The Planning Inspectorate  
3/18 Eagle Wing  
Temple Quay House  
2 The Square  
Bristol, BS1 6PN

20<sup>th</sup> May 2015  
Ref: EN010048

## **Response from the Yorkshire Wildlife Trust to the Inspectors first written questions for the WRCCS project.**

Figure 1 Landscape and ecology mitigation plan

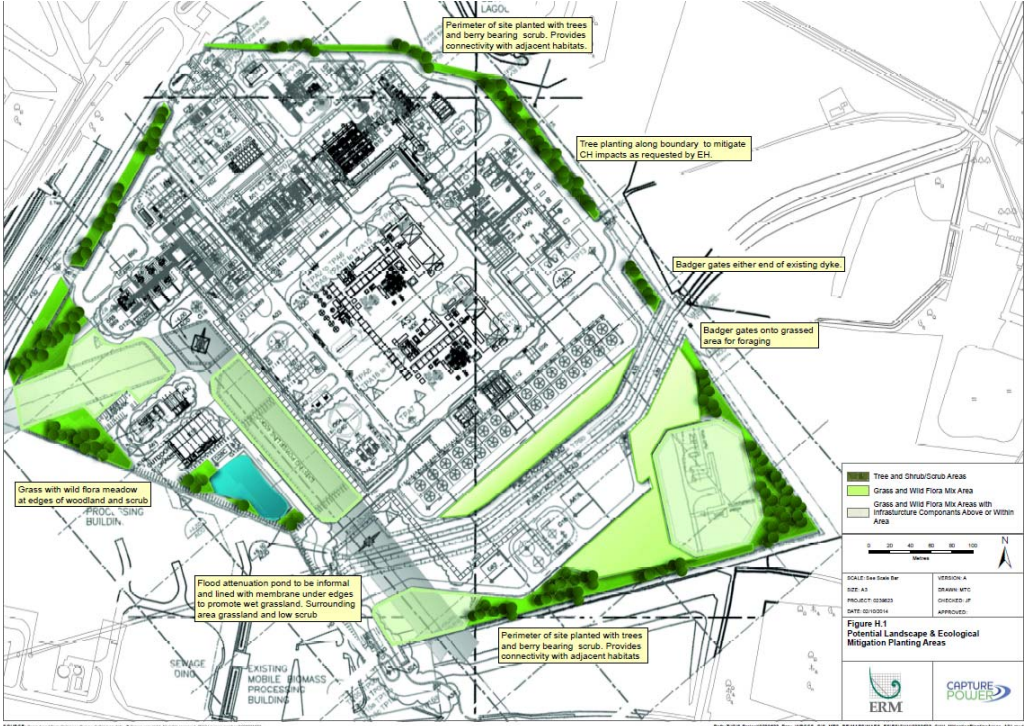
The Trust is prepared to accept that a complete offsetting calculation may not be essential but there is a need to provide detail to show that there is not a loss of biodiversity. The calculation provided to the Trust, of habitats lost and mitigation provided, (and included with our comments) does show that there is a net loss of habitat and a lack of provision of mitigation or compensation. There are particular shortfalls in the provision of ponds, wetland, and swamp habitat. The Yorkshire Wildlife Trust has been discussing with the applicants alternative possibilities to compensate for lack of mitigation including areas outside the DCO. There would be opportunities to provide not only mitigation but a large area of habitat creation could also provide ecosystem services such as flood alleviation and green infrastructure.

The use of this pond to fully mitigate for both flood risk and biodiversity cannot be justified. Ponds of this type do have some value for wildlife but not as much as ponds which are purely designed for biodiversity. There is a lack of pond, swamp and wetland habitat within the proposed mitigation area as shown by the habitat calculations and more should be provided. In order to function effectively the flood attenuation pond will need to have low water levels to accommodate extra water from storm events. The water level could therefore rise and fall erratically. There is also a likelihood of polluted water entering the pond from roads and hard standing areas. There may also be a need to regularly remove silt from the pond as it will be swept in from the surrounding area which will reduce the wildlife value. The pond is therefore unlikely to

fully mitigate for the loss of pond habitat due to the combination of the limited area of the pond and the need for it to operate effectively for flood attenuation.
